**MASTER DEVELOPMENT
DRAINAGE PLAN
FOR
DAVIS RANCH SKETCH PLAN,
EL PASO COUNTY, COLORADO**

June 2023

SKP232

PROPOSED DRAINAGE MAP
DAVIS RANCH
JOB NO. 25274.00
06/30/23
SHEET 1 OF 1

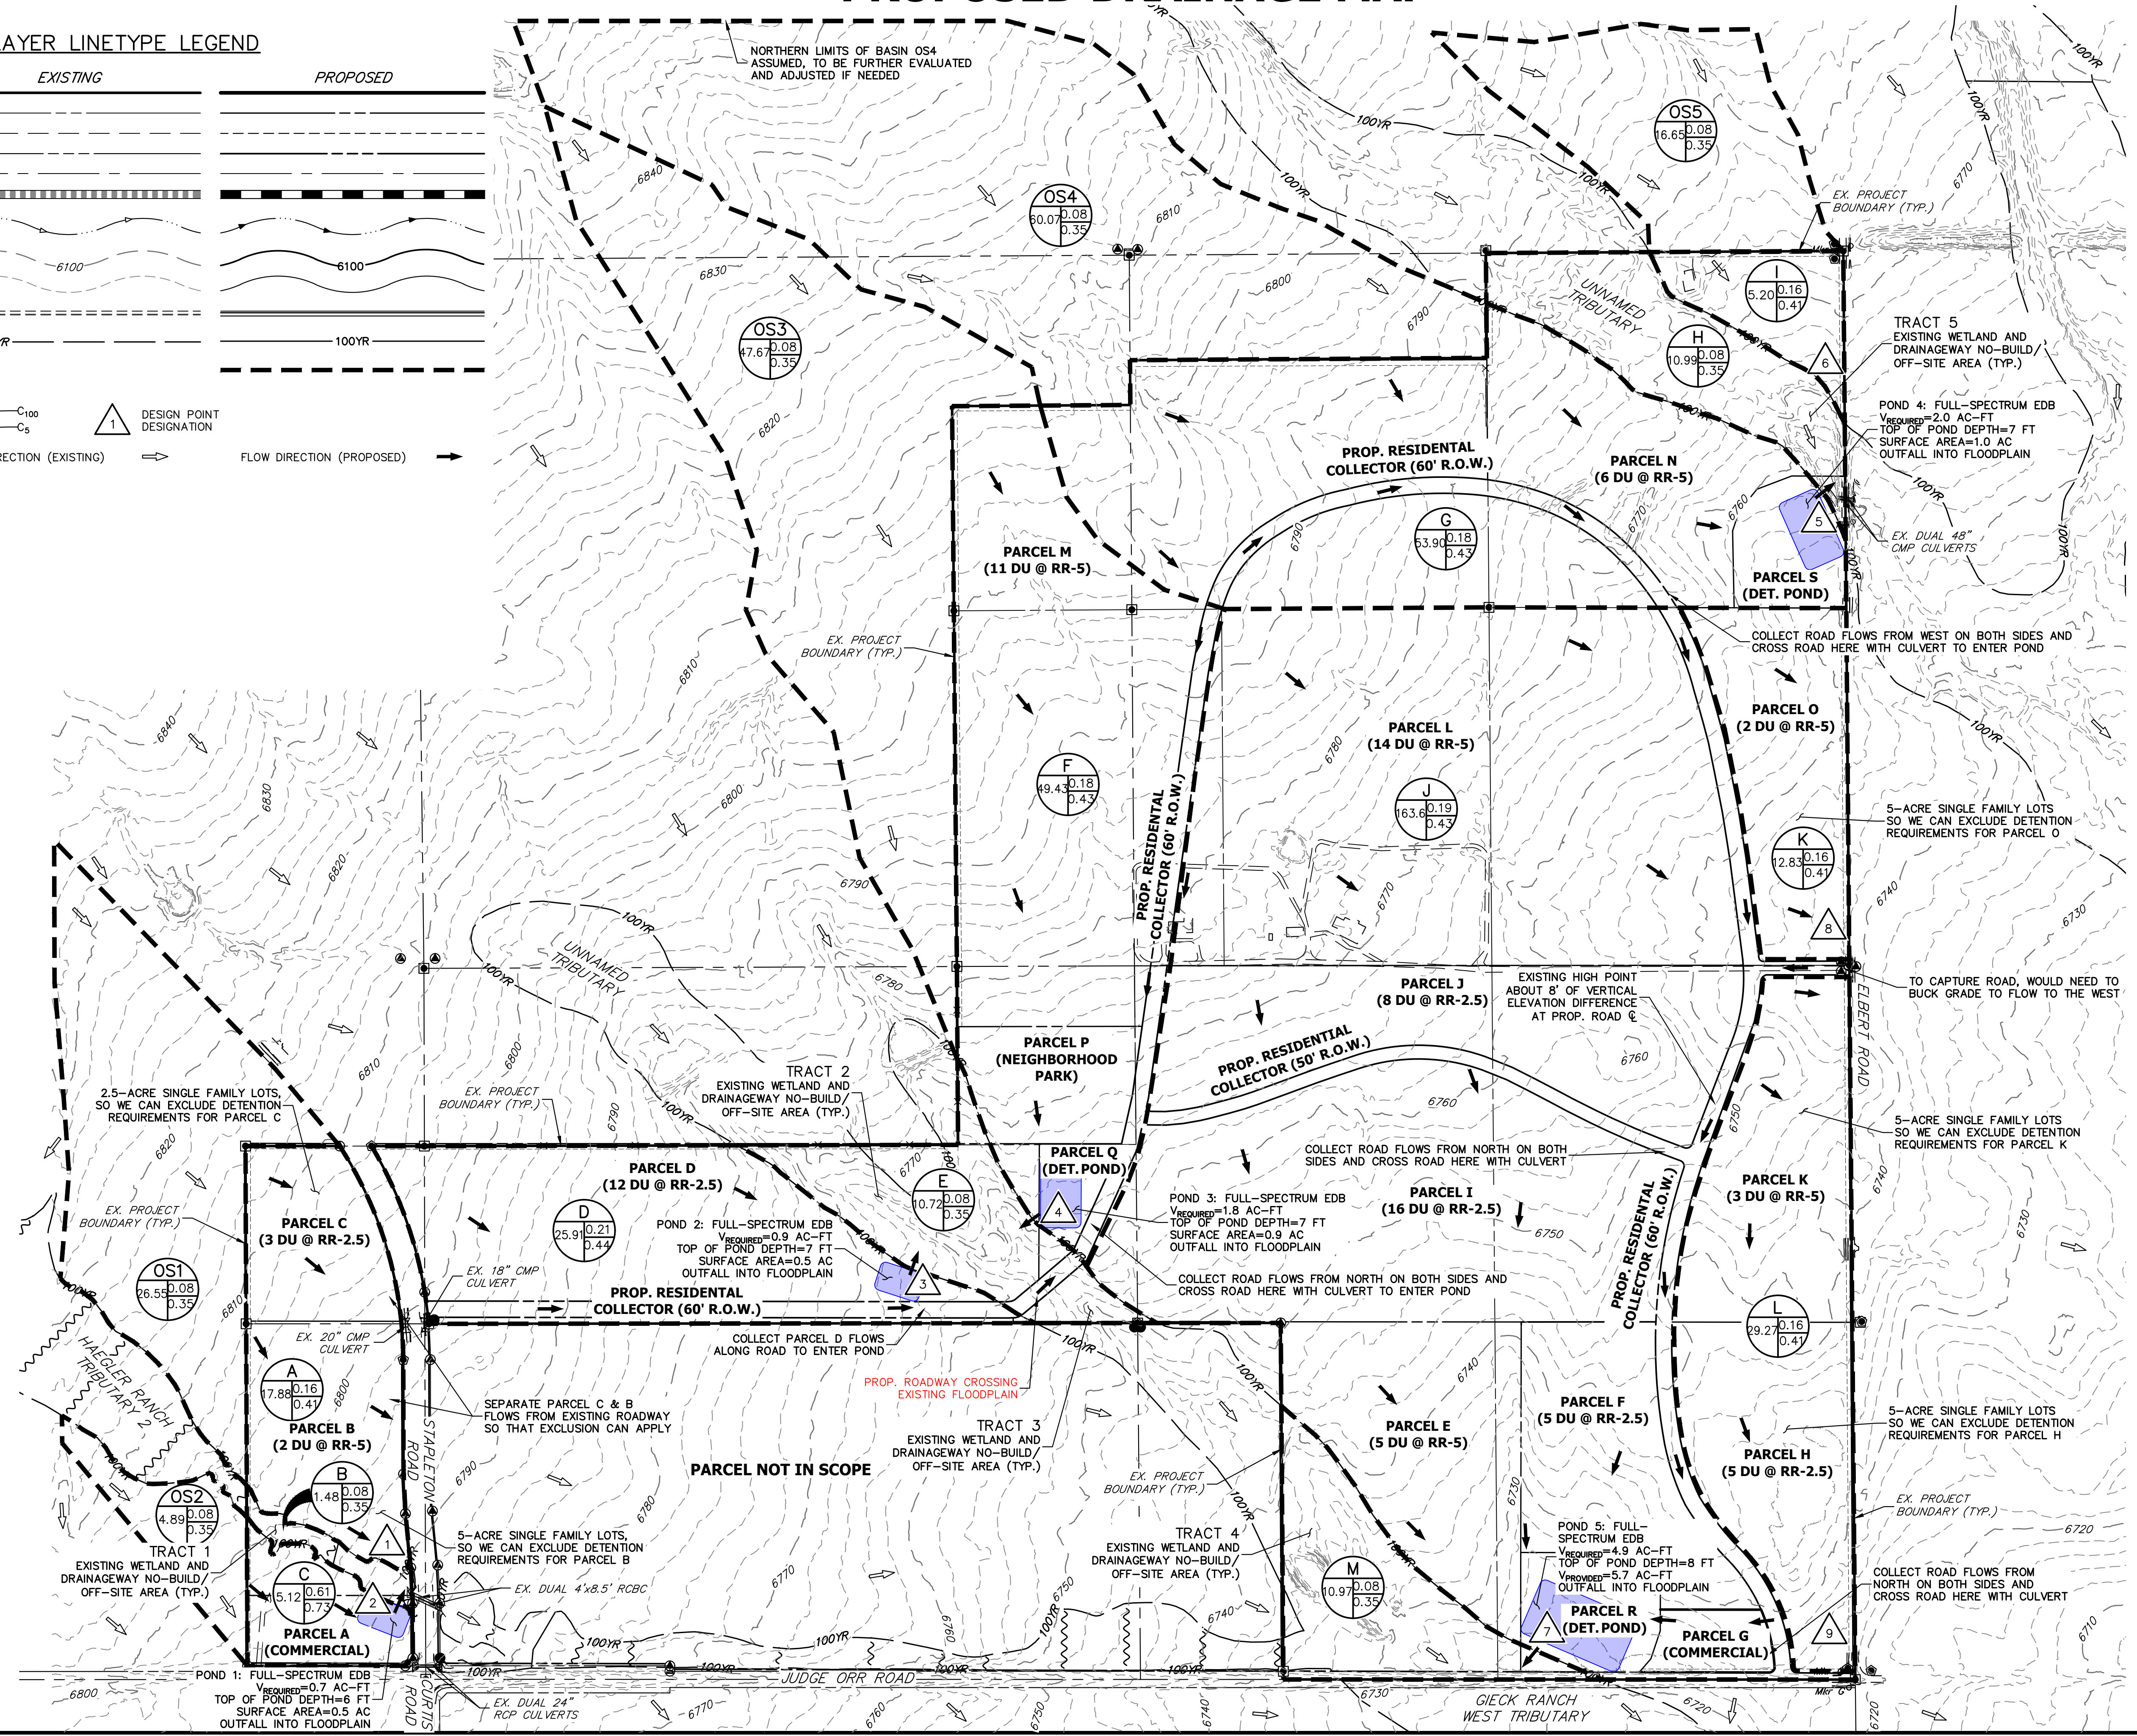
this should be 4'x8.5' RCBC as indicated
in the drainage plan and as discussed
previously in the narrative. *Revise*

JR Response: Addressed

PROPOSED WATER QUALITY MAP
DAVIS RANCH
JOB NO. 25274.00
06/30/23
SHEET 1 OF 1

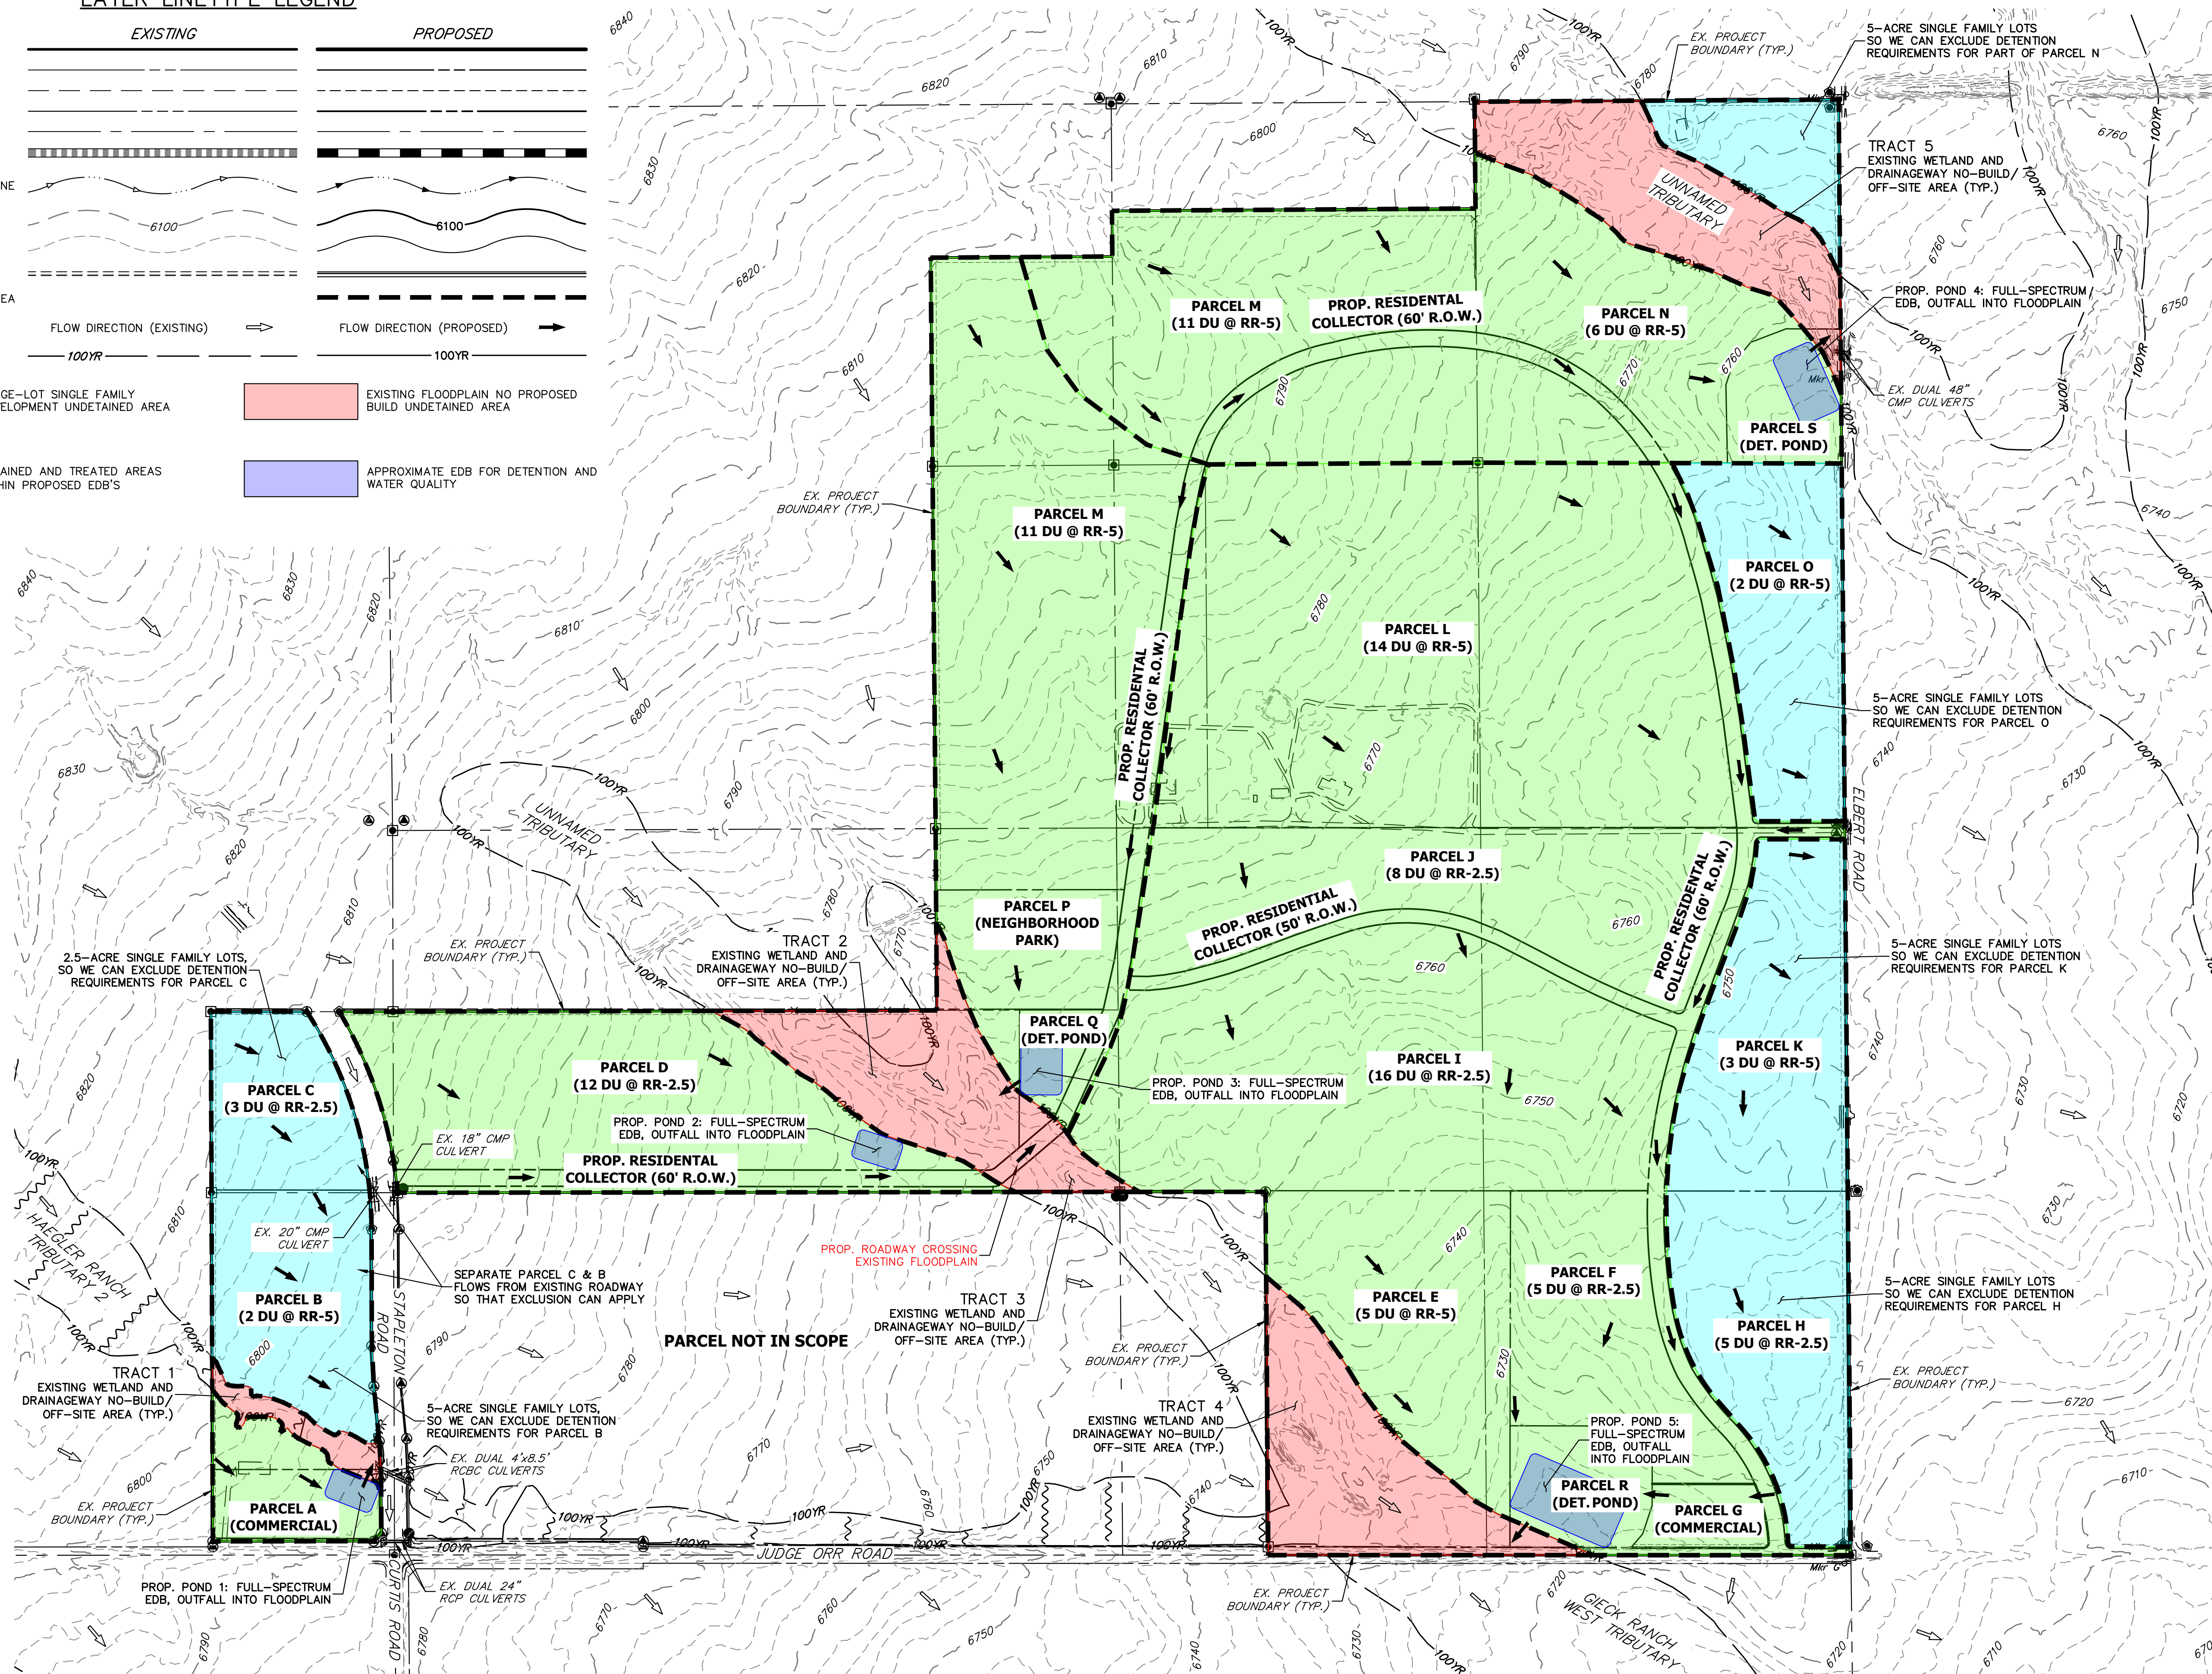
This exclusion is for water quality only. Increase in flows for this basin will still have to be mitigated. Please discuss mitigation measures for this basin.

This exclusion is not a quality improvement. Increase in flows for this basin will still have to be mitigated. Please discuss how increased flows from this basin will be mitigated.

JR Response: Addressed

JR Response: Addressed
